Application for removal or variation of a condition following grant of
planning permission. Town and Country Planning Act 1990.
Planning (Listed Buildings and Conservation Areas) Act 1990

Demolition of existing WC's and education centre. Erection of new education building, new WC's, canopy and associated landscaping works. (amended plans received 11.12.18).

2018/2479/FUL

title Proposed Trailer Canopy  
date 18.09.18  
scale 1:100 @ A3  
drg 1118/034 rev .

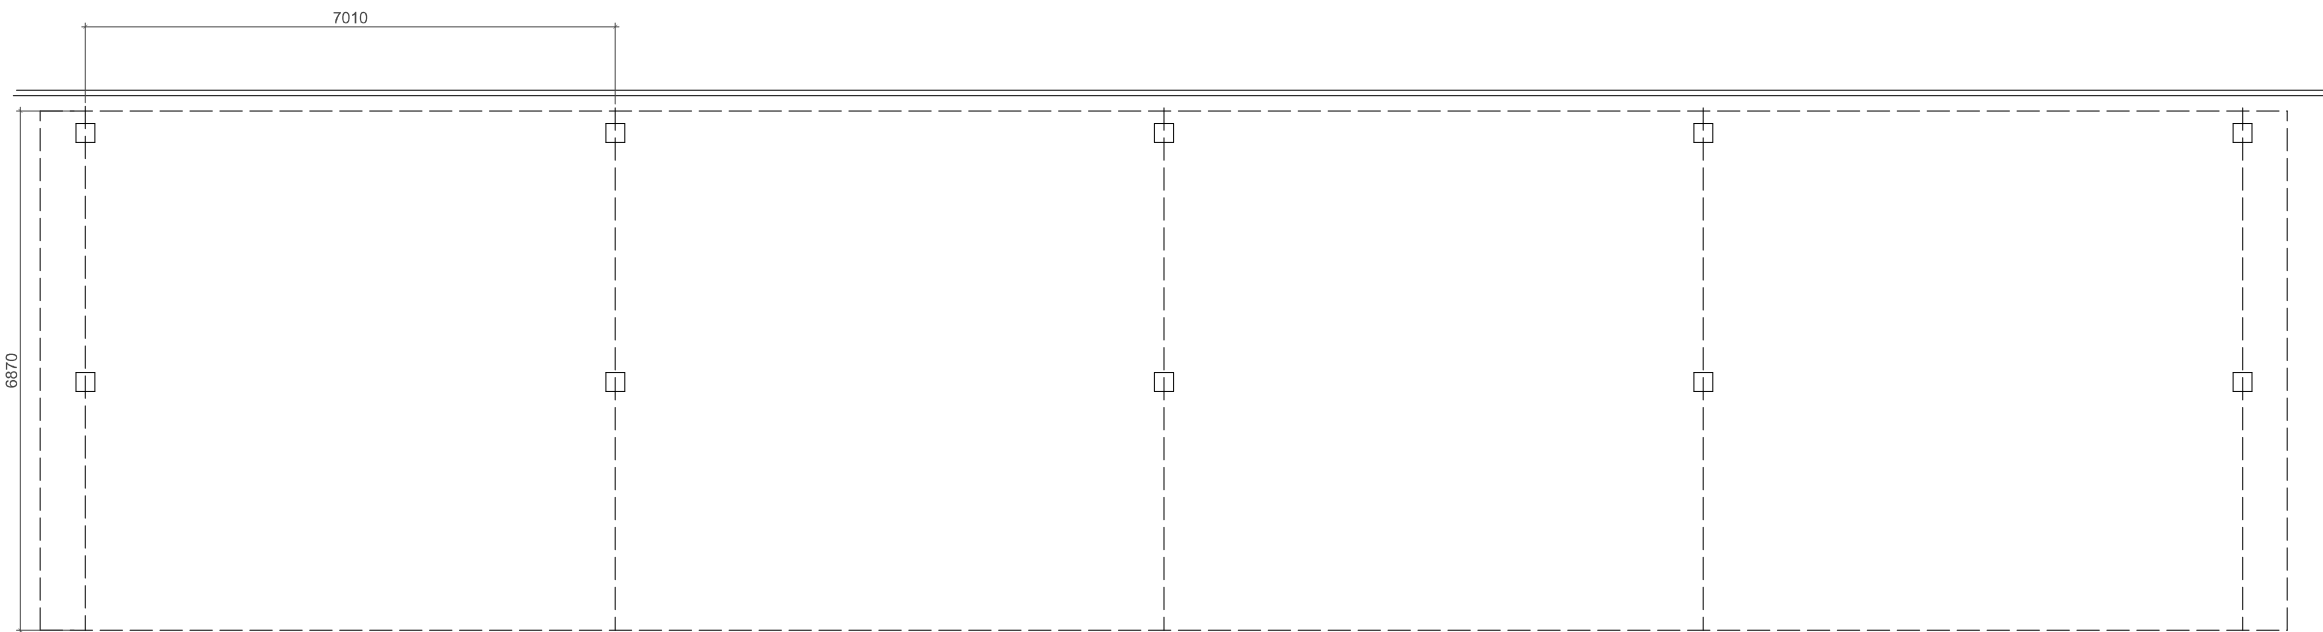
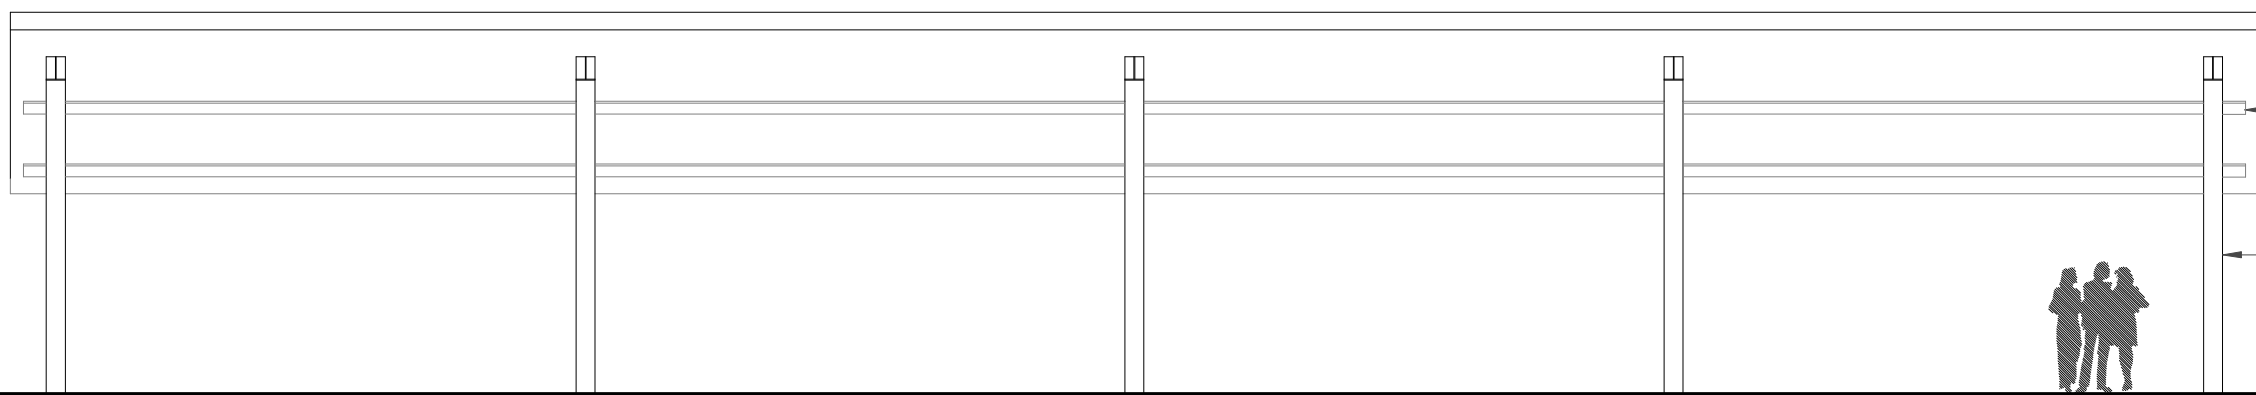
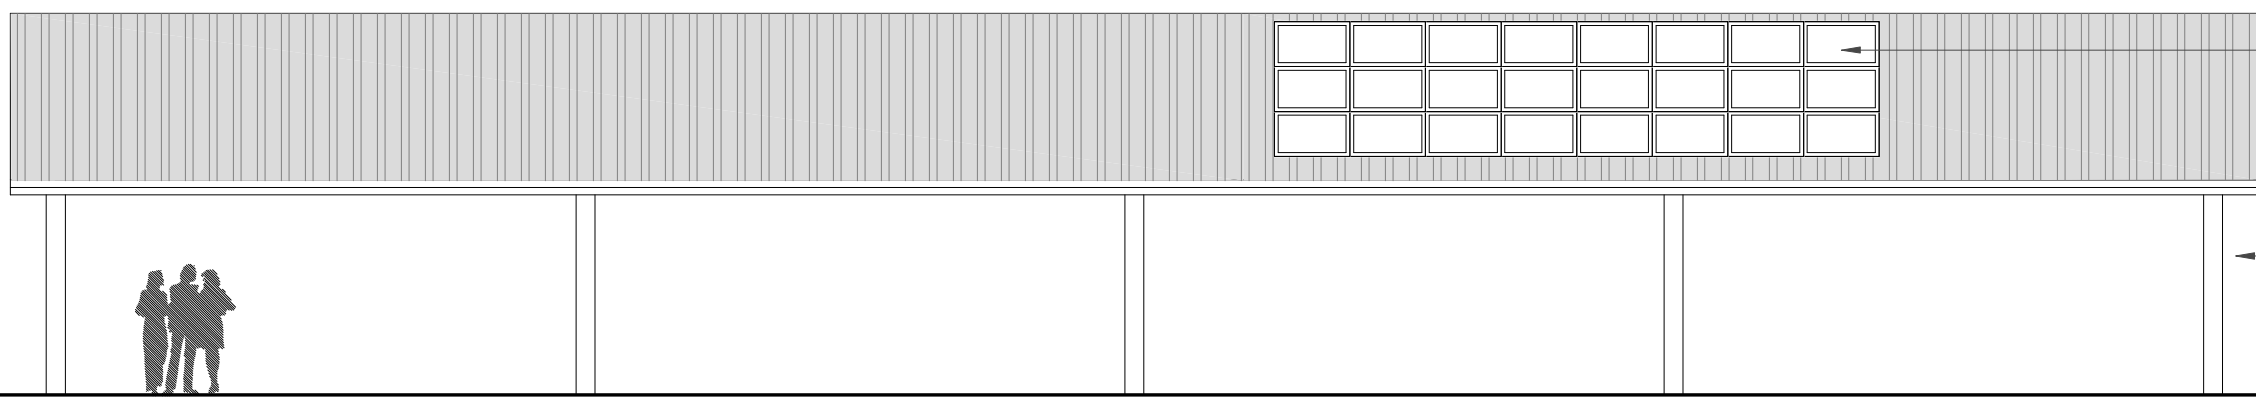
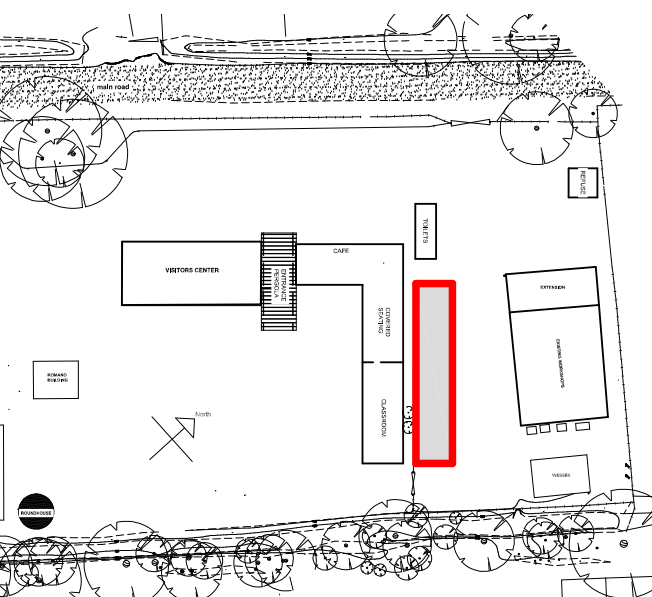
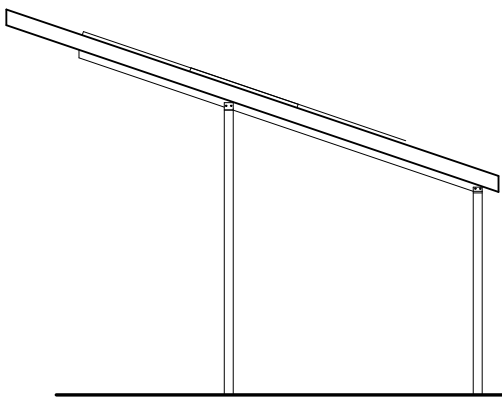
- Revised canopy over cafe seating area - the canopy will now join classroom building and extended cafe.
- Pergola to demarcate main entrance.
- Relocation of WC block
- Relocation of refuse store
- Addition of a trailer canopy near the office building, adjacent to classroom building.
- Minor revision to hard landscaping near the cafe
- Inclusion of timber perimeter fence around cafe, covered seating area and classroom.
